**Consultation Response from: KC Environmental Health (Pollution & Noise Control)**
**2023/91251 - adj, 18, Wells Road, Thornhill, Dewsbury, WF12 0LE**
**Discharge conditions 6 (parking), 7 (retaining walls/ structures), 8 (wastes), 9 (bat box) 10 (evc), 11 (Phase I Desk Study Report), 17 (drainage) on previous permission 2021/90209 for erection of detached dwelling**
**Date Responded:  
8<sup>th</sup> June 2023**
**Responding Officer:  
NH**
**Responding Ref:  
WK/202314249**

DRAWING TITLE
Site Plan

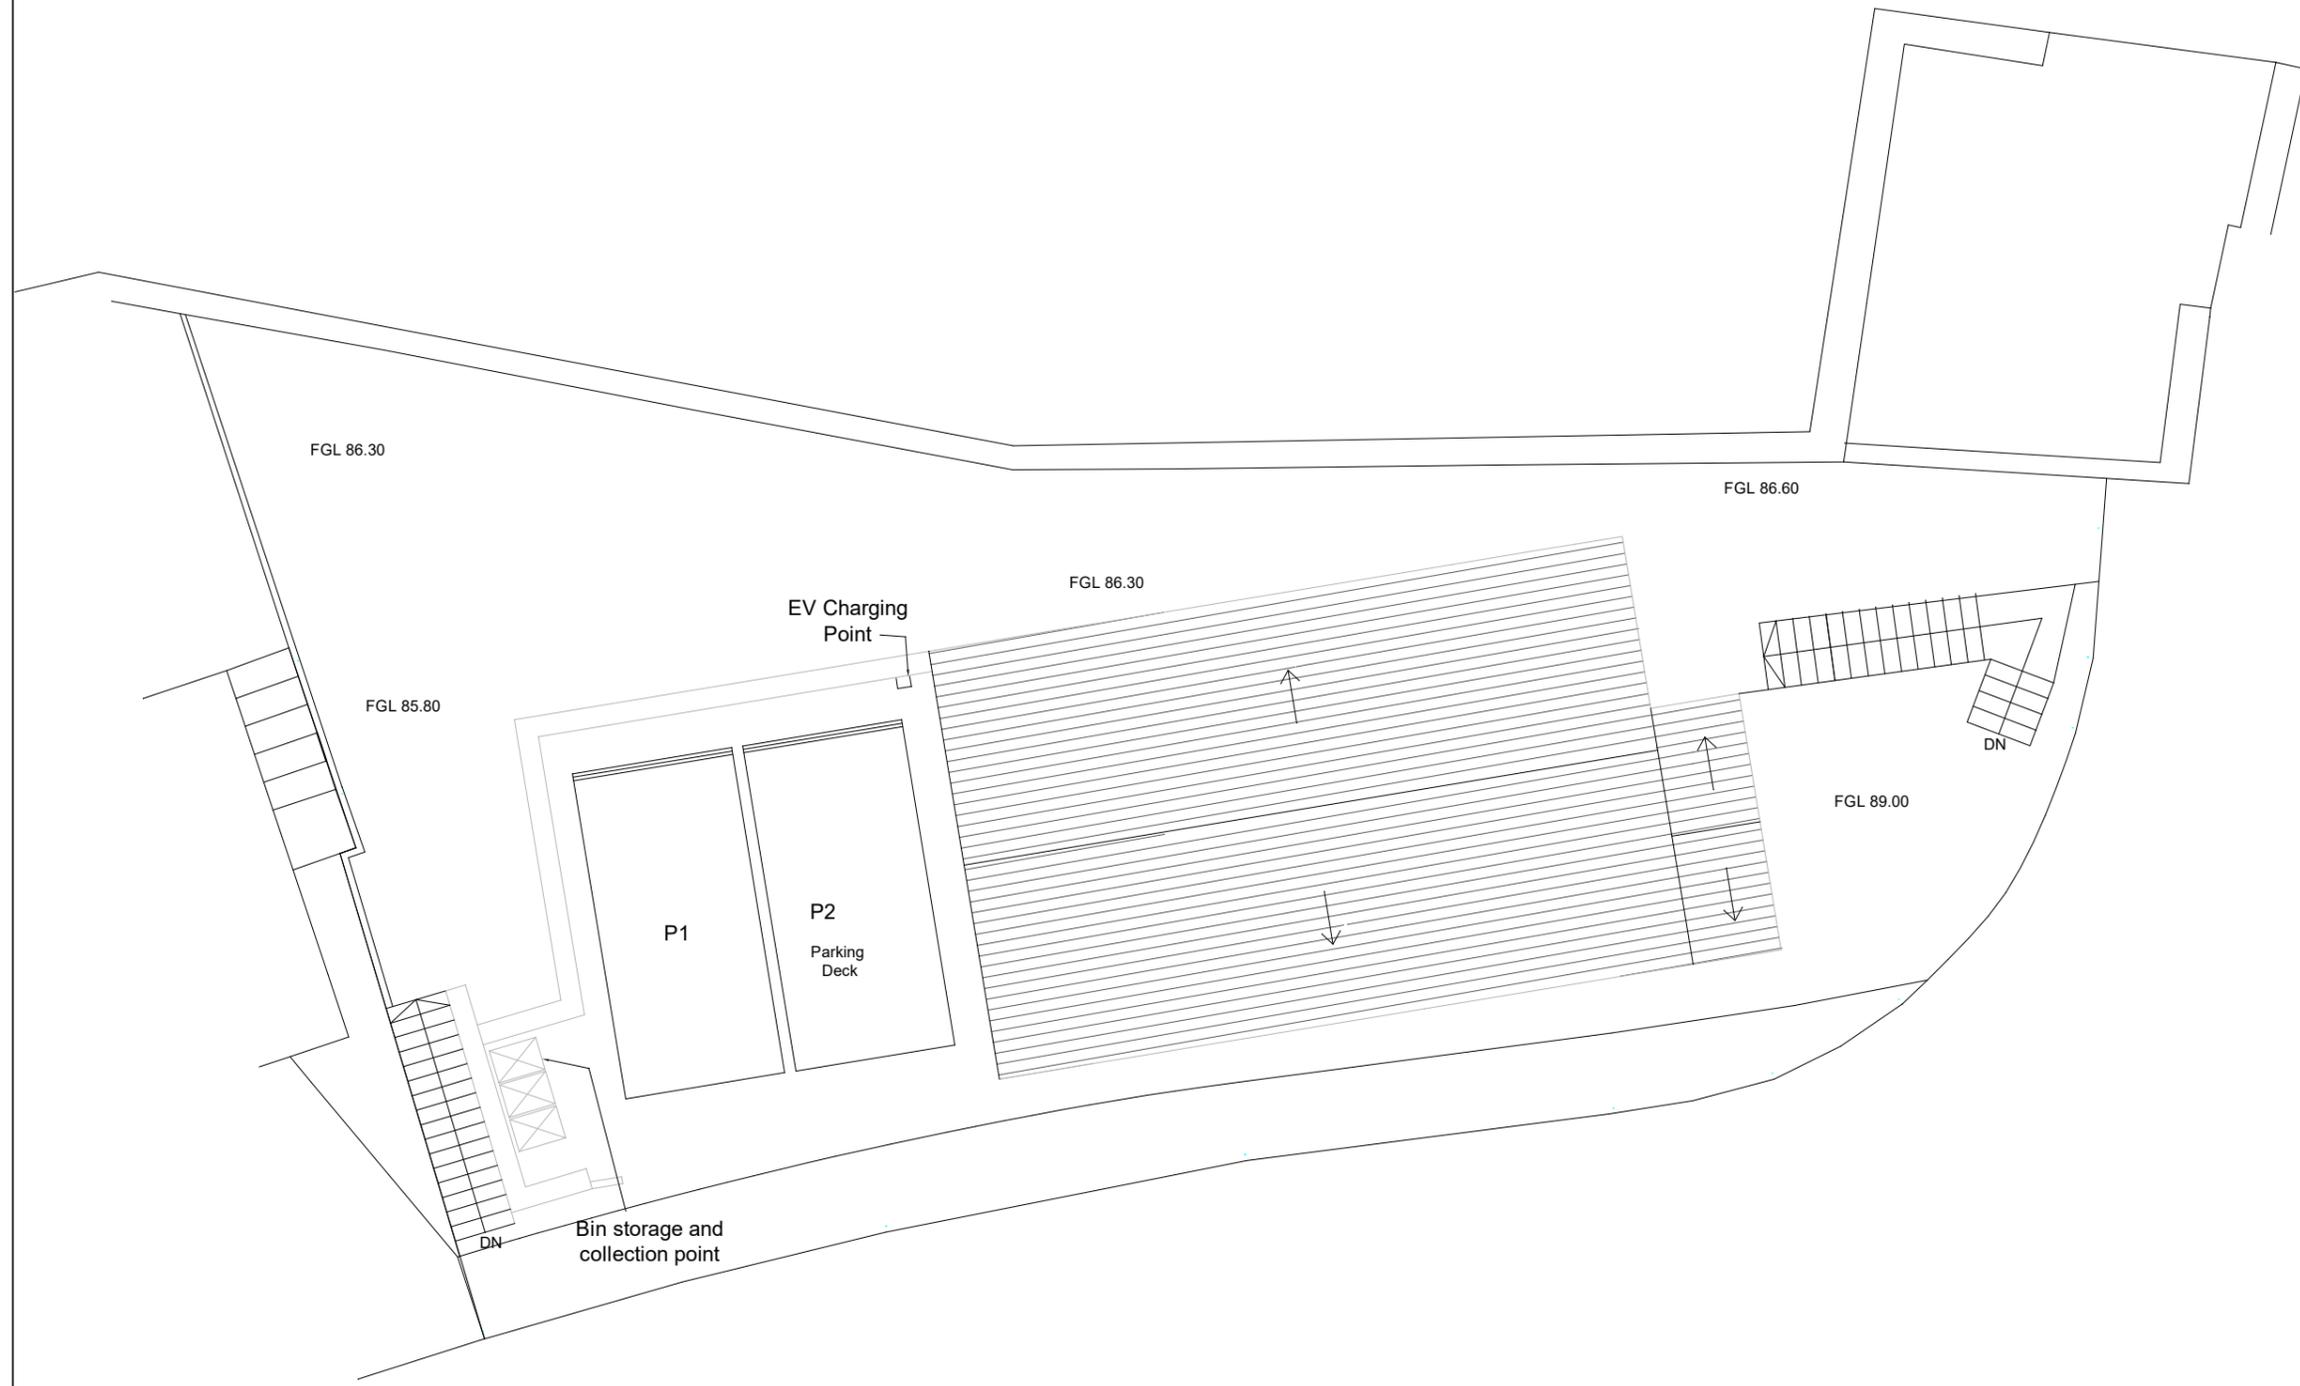
To discharge Condition 10, The Site Plan by Faisal Building Solution (No Date, Ref: E20054) shows the proposed installation of a charging point. Electric vehicle charging provisions for new residential buildings are now a requirement under Building Regulations. Notwithstanding, the condition should remain until the construction is complete.

The Site Plan by Faisal Building Solution (No Date, Ref: E20054) shows the proposed installation of a charging point and is accepted. Notwithstanding, the condition should remain until the construction is complete.
